A303 Amesbury to Berwick Down Case Team
National Infrastructure Planning
The Planning Inspectorate
Temple Quay House
Temple Quay
Bristol
BS1 6PN
Reference : 20019751
30th August 2019

**Application by Highways England for an Order Granting Development Consent for the A303 Amesbury to Berwick Down
Amesbury Abbey Group Limited's Response to Highways Agency's Comments**

I represent Amesbury Abbey Group who are the owners of Amesbury Abbey, Grade I listed building and 8 ha of registered park and gardens Amesbury Abbey Park Grade II*.

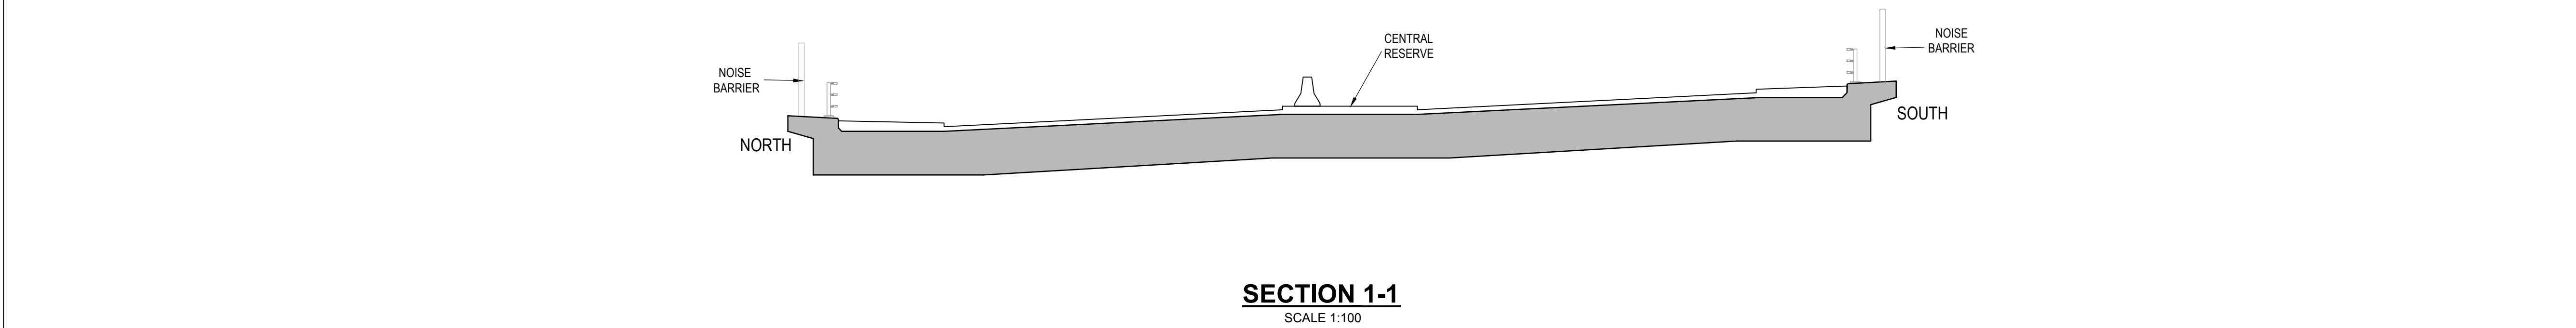
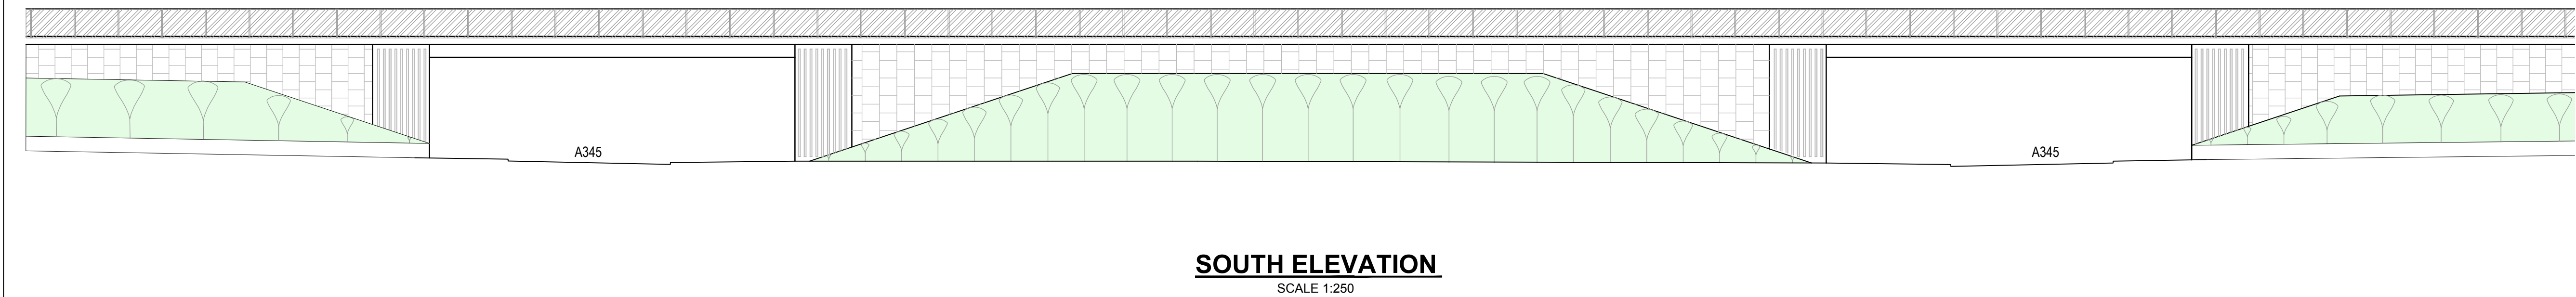
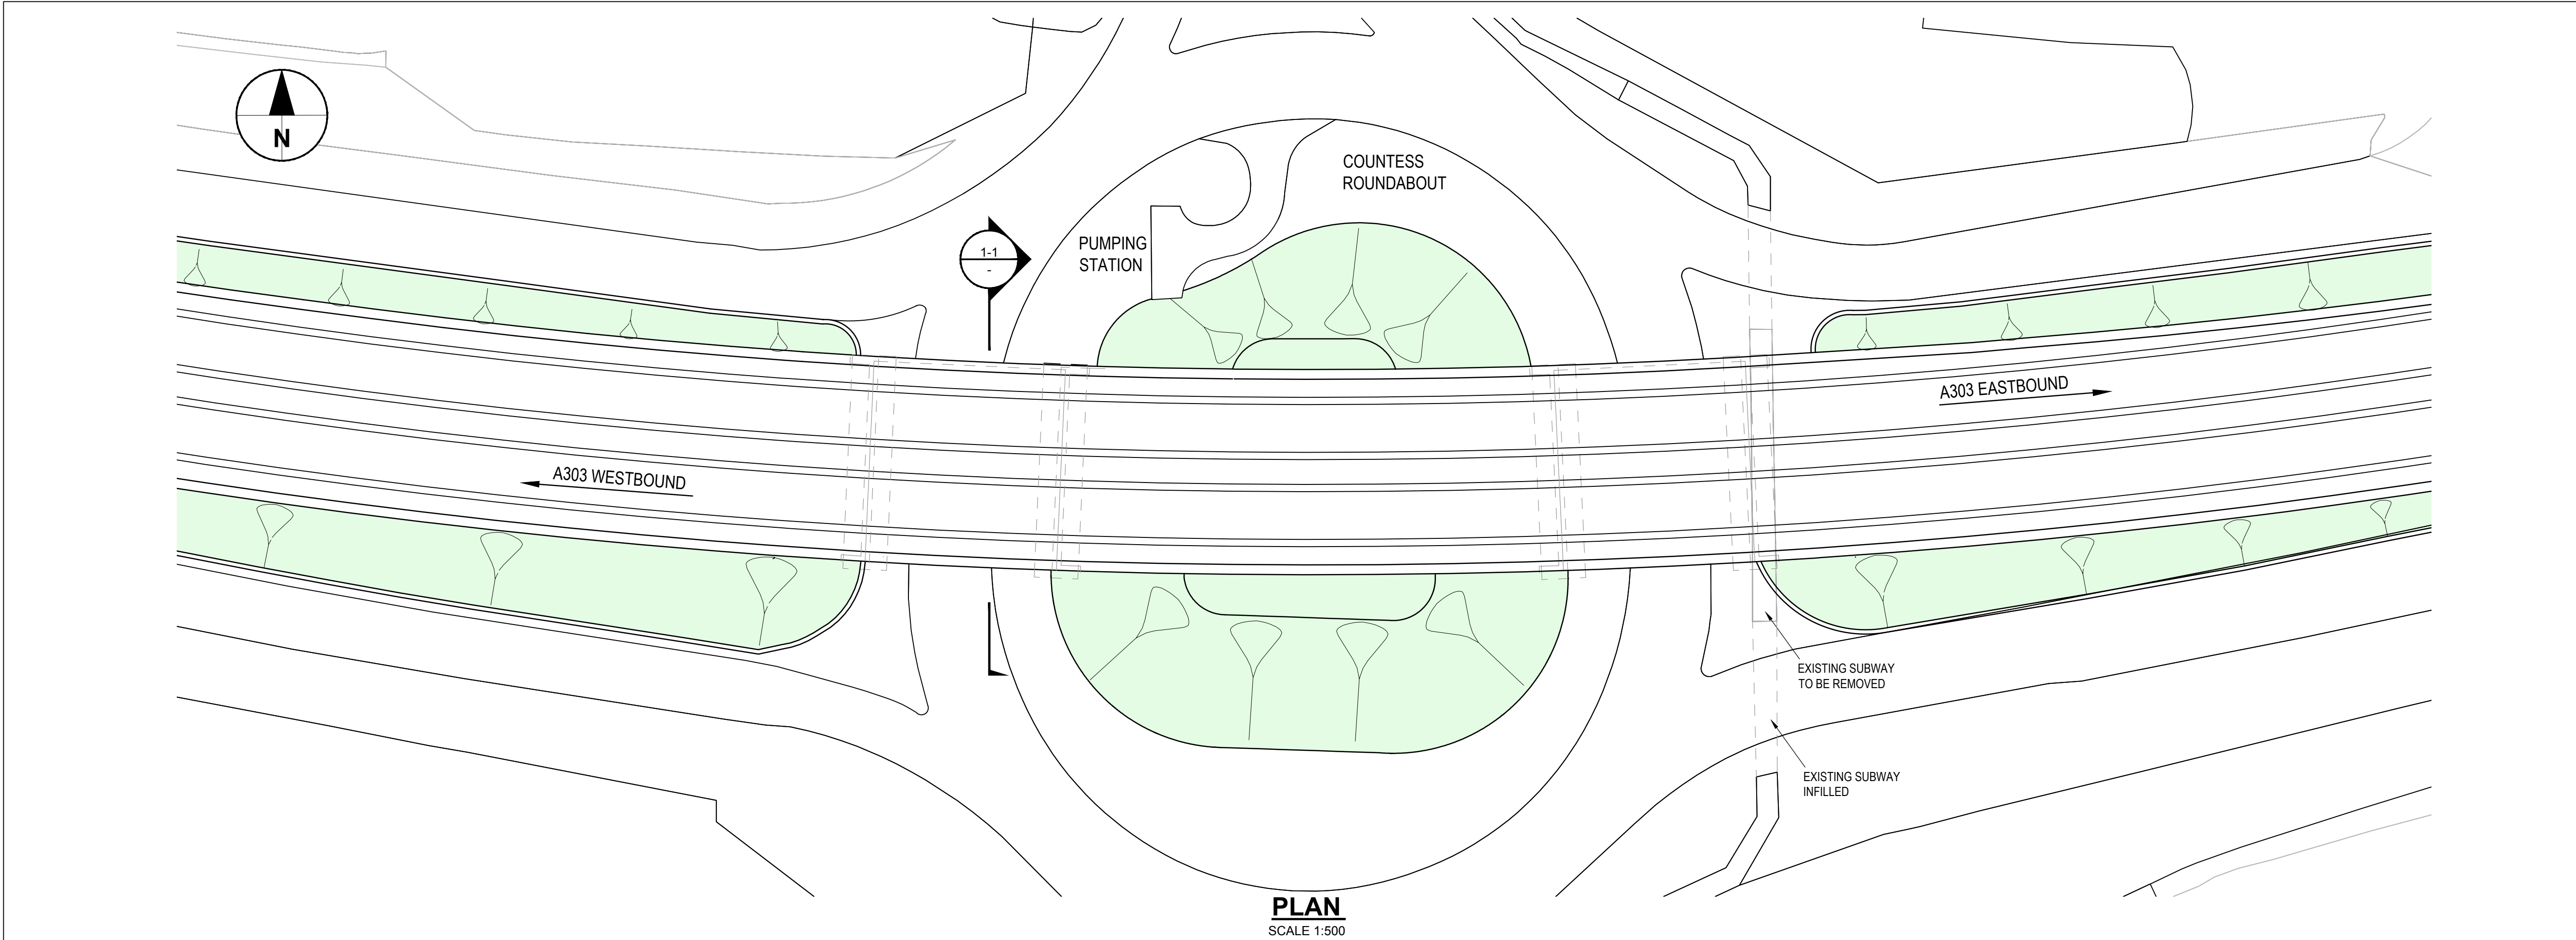
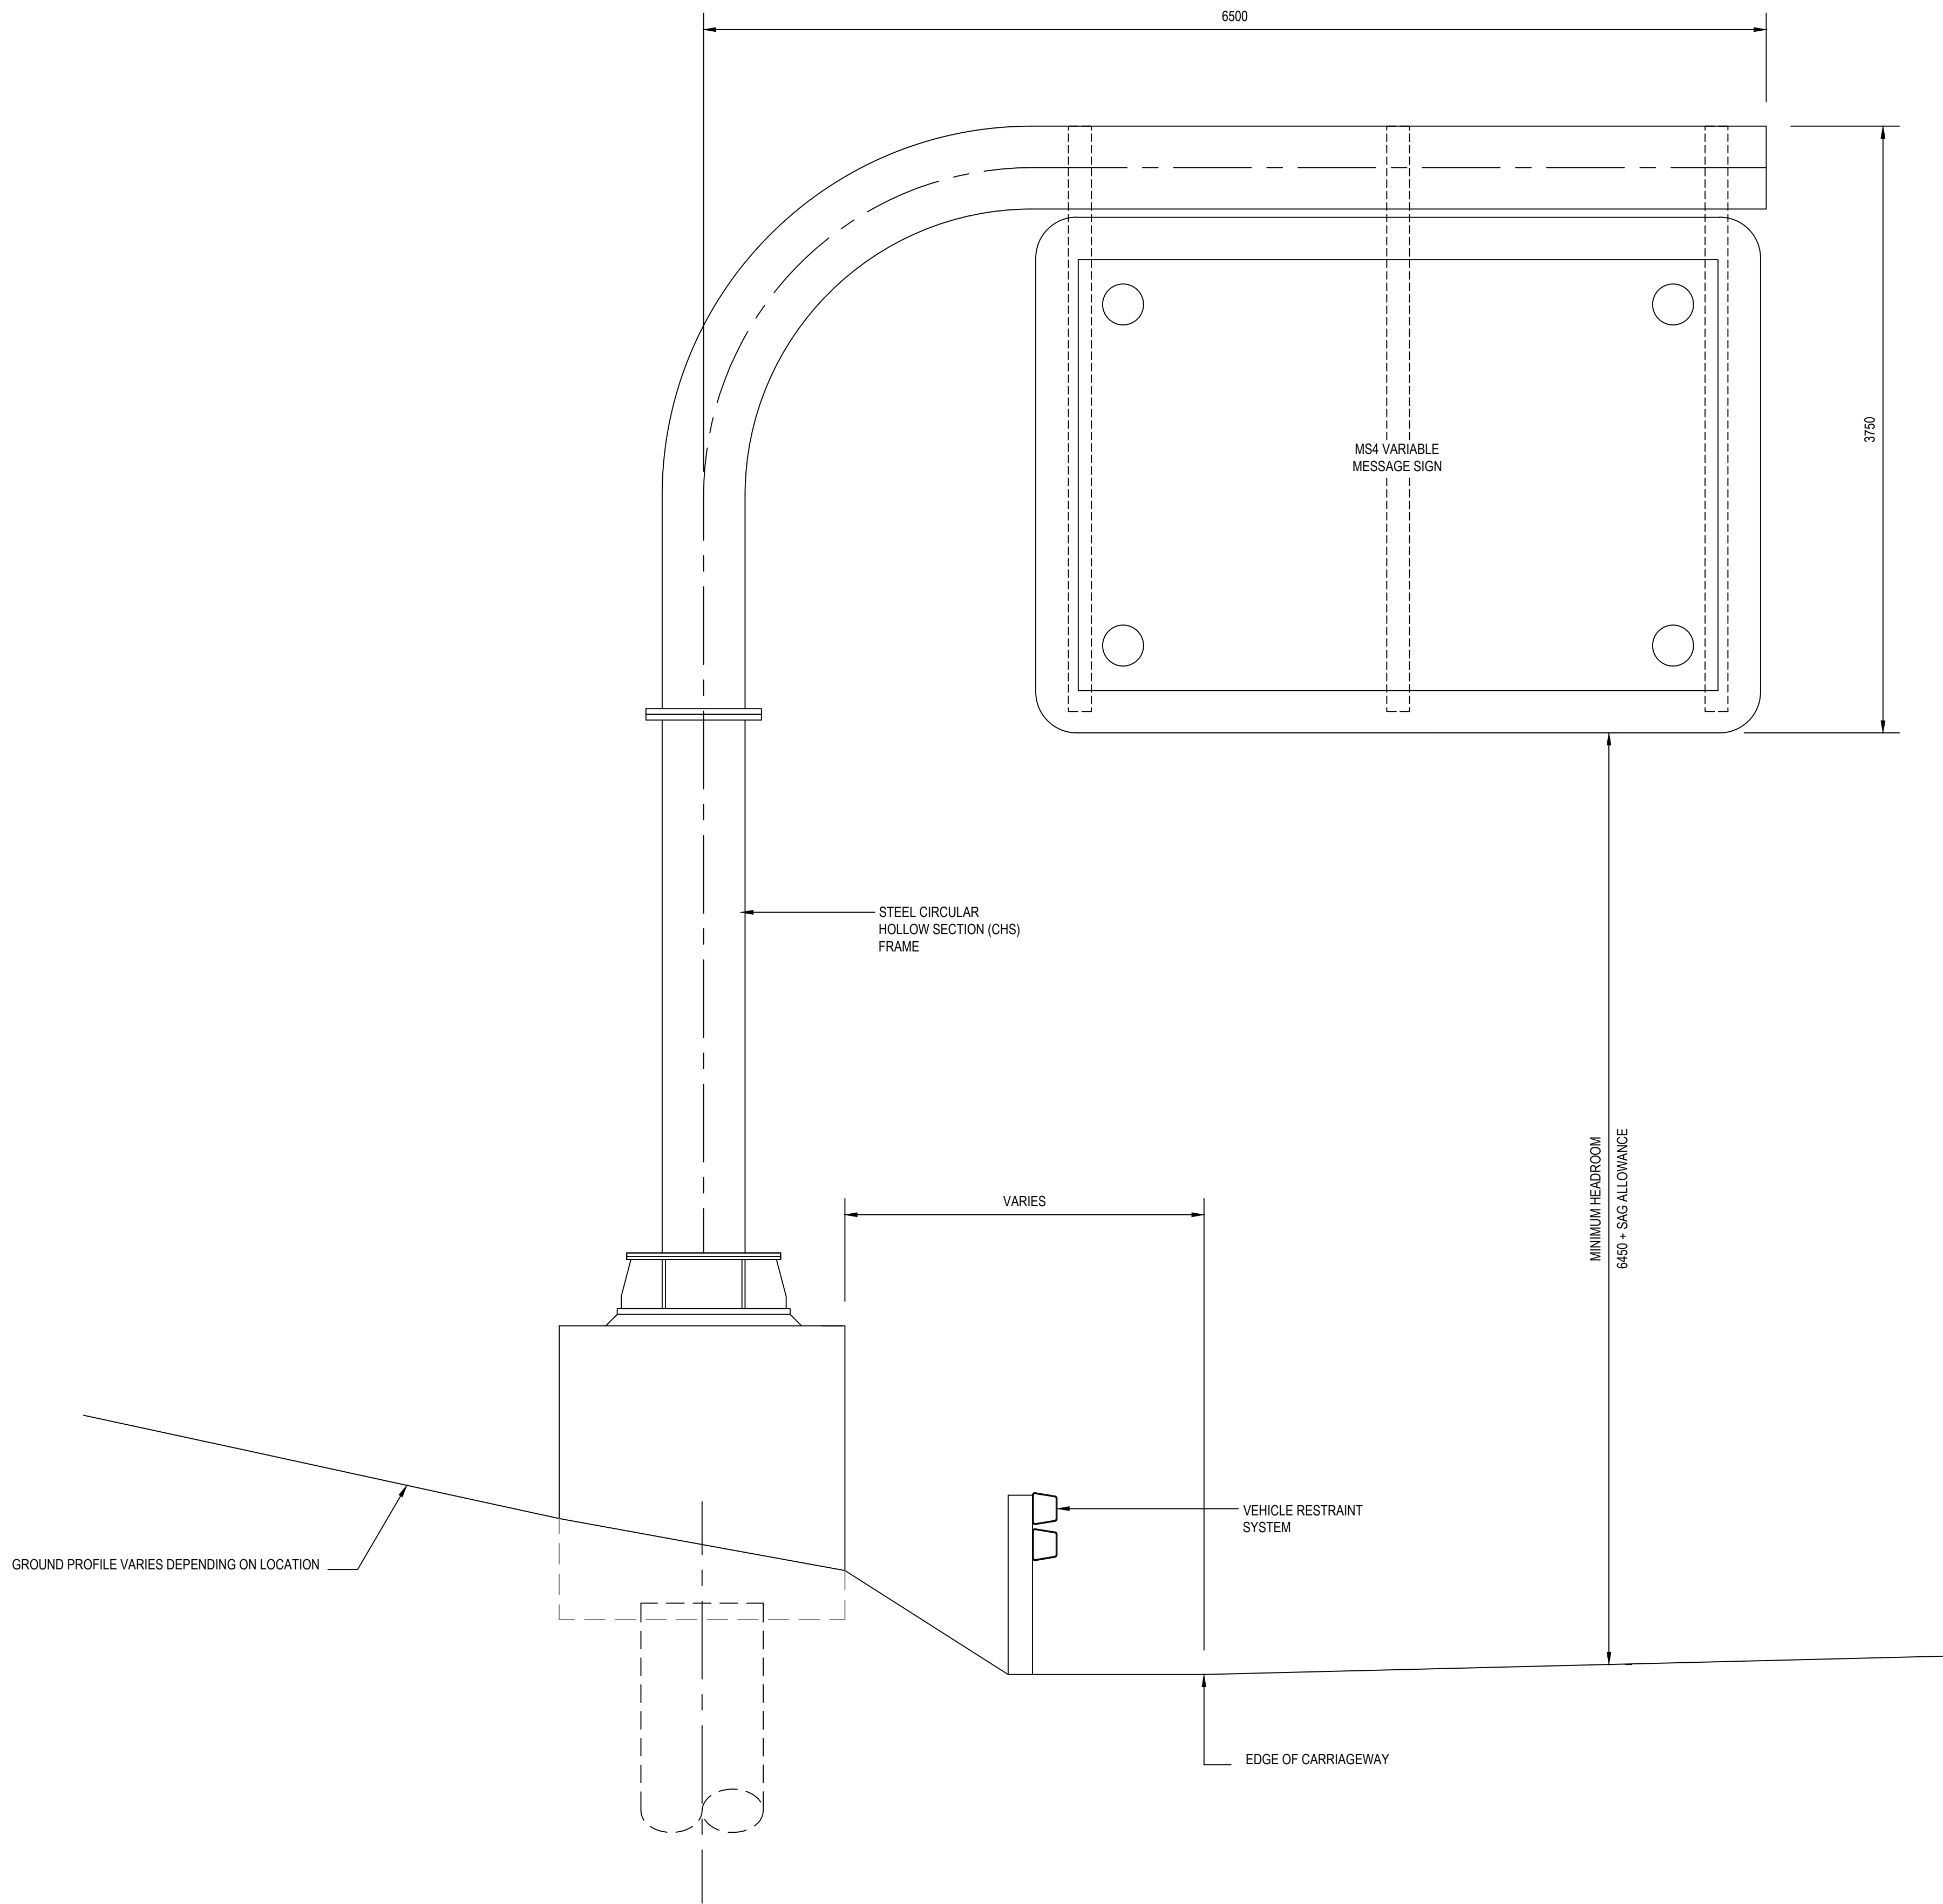
They also refer to the drawing at sheet 12 of 13 APP-017 this is clearly annotated in the notes "The design and location of the structure is shown here for illustrative purposes only" and as I reported to the Examination it was made clear to me at the Accompanied Site Visit by a HE officer that the height and design of the flyover were not yet known so it is hard to see how its landscape impact can be assessed.
